Pymble PLC

**PLC Grey House Precinct**

**Accessibility Review Report**

19 July 2021

GENERAL ARRANGEMENT  
PLAN - LEVEL 00

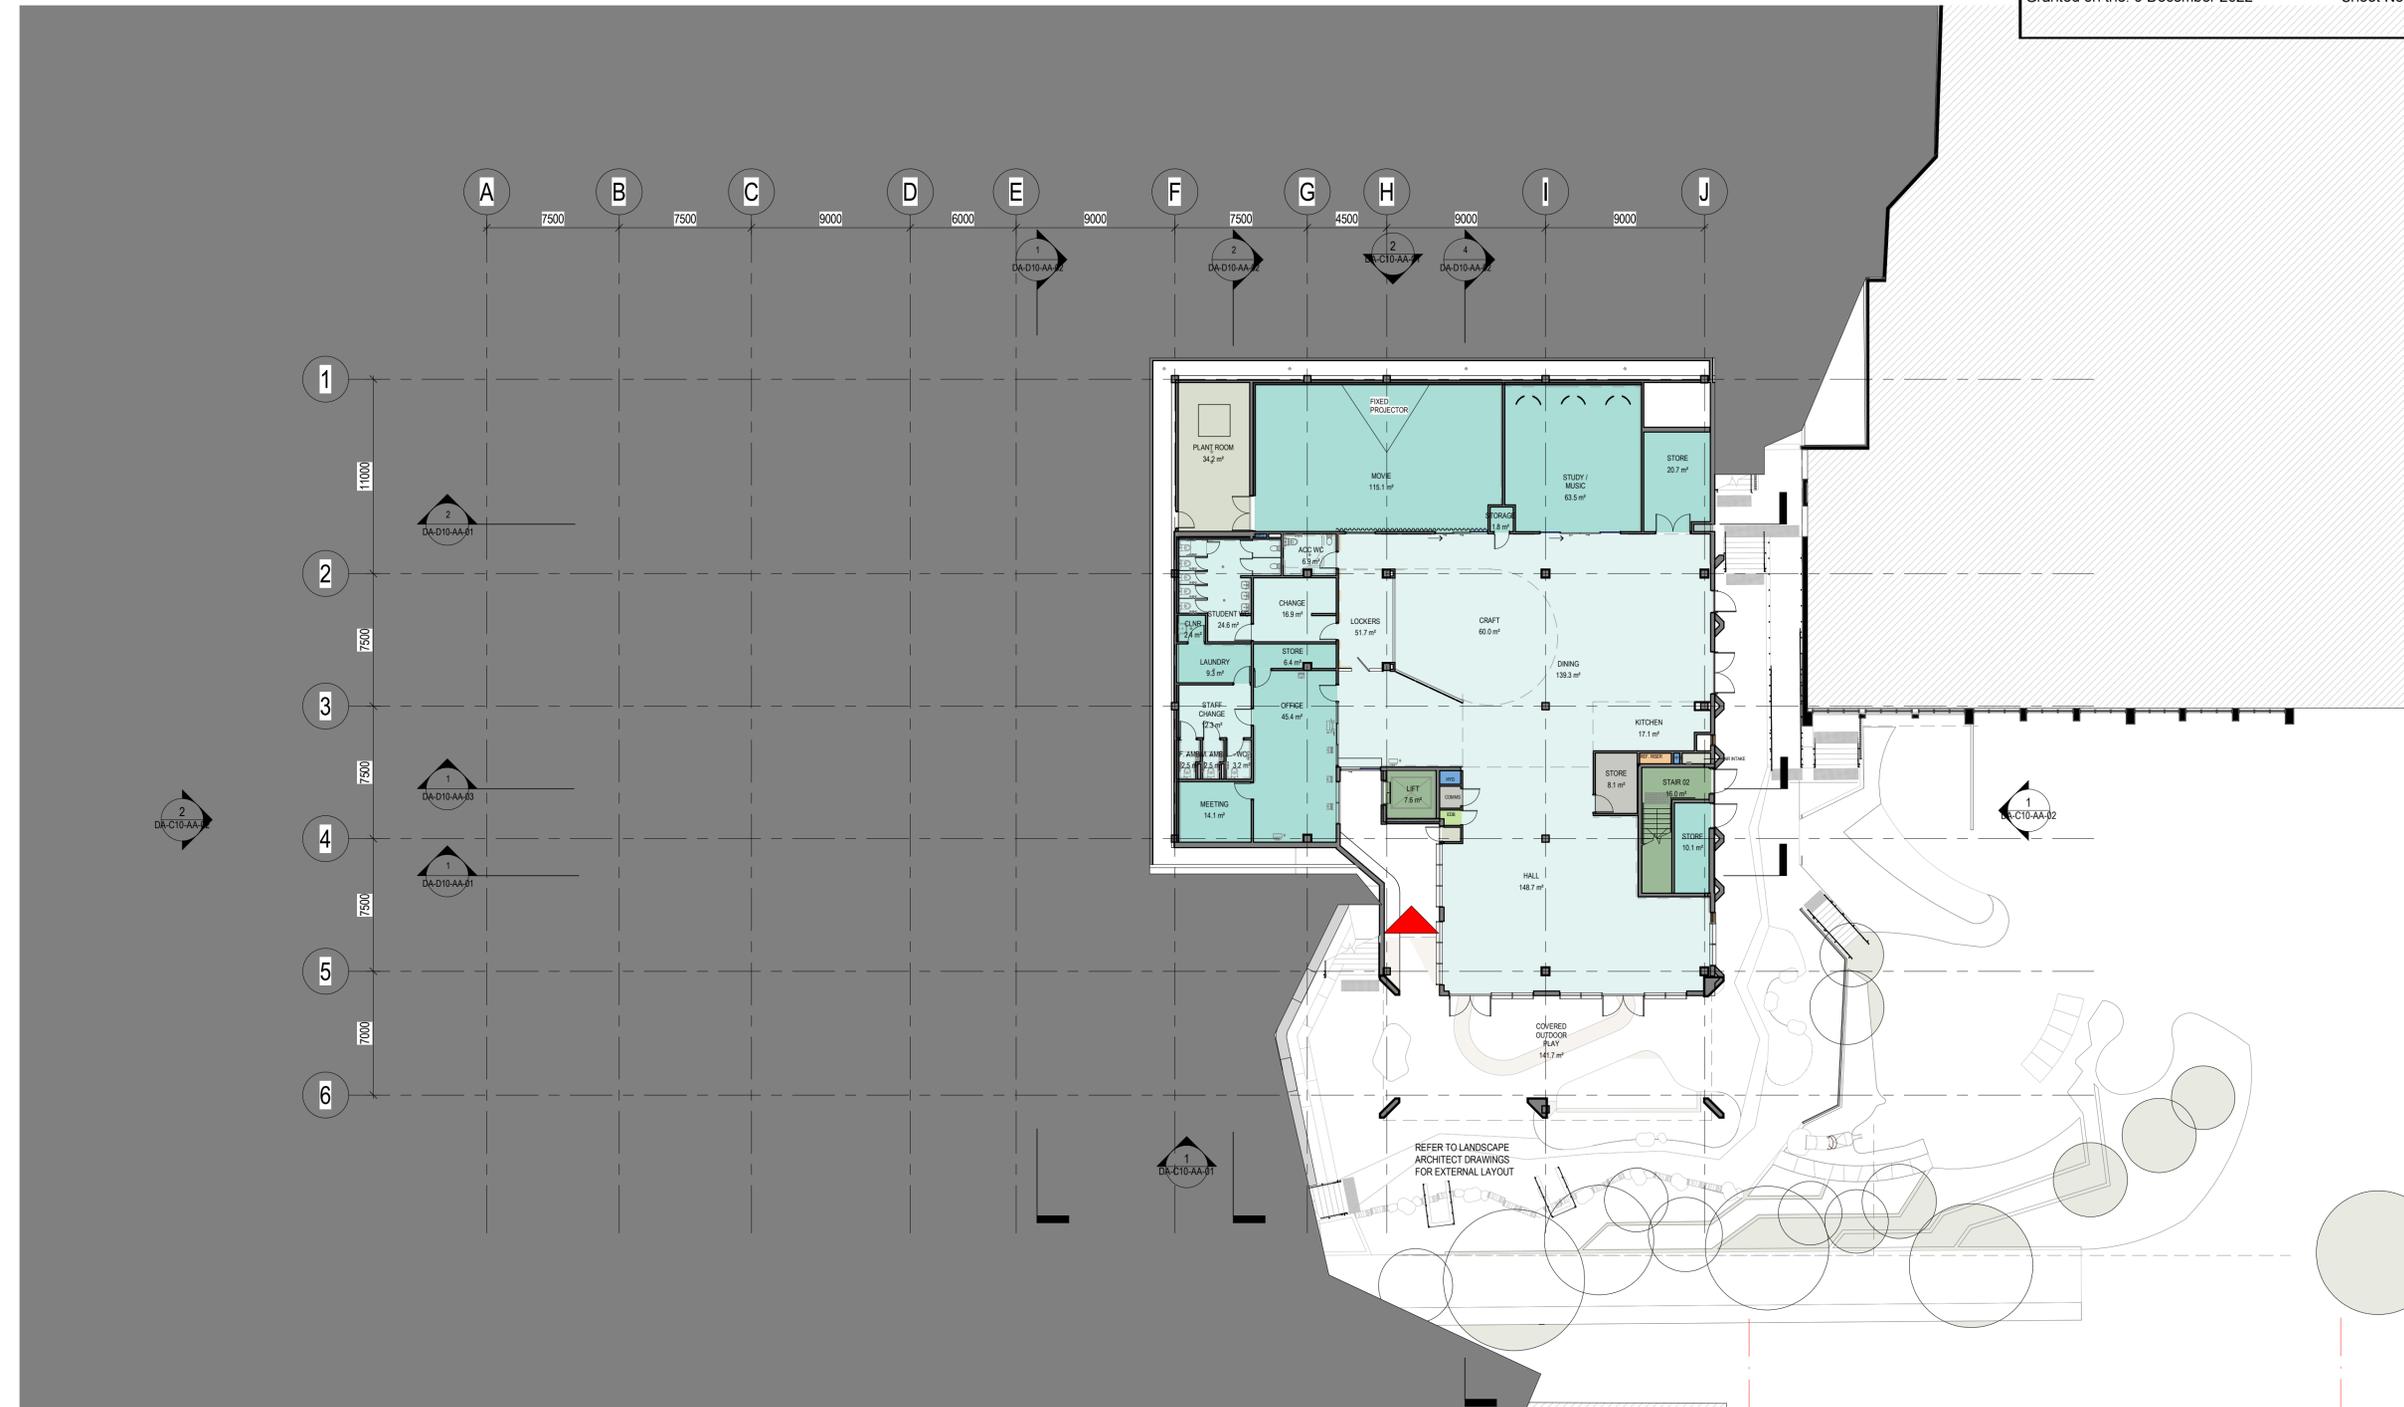
Provision of an off-set tread at the base of stair flights or an extended mid-landing that will allow a 300mm extension clear of egress route is considered appropriate for achieving a consistent height handrail (without vertical or raked sections). Such an off-set tread configuration has not been shown at the majority of stairs and would appear to be possible elsewhere, subject to further detail design.

On the basis of the current level of detail, all access requirements appear capable of achieving compliance subject to recommendations and comments on markups being addressed at subsequent design stages. Note off-set tread configuration has not been shown, refer markups. As advised, this will be reviewed and comply at further design stages.

Accessible carparking requirements has not yet been provided. Refer mark-ups for further comments. As advised, this will be reviewed and comply at further design stages.
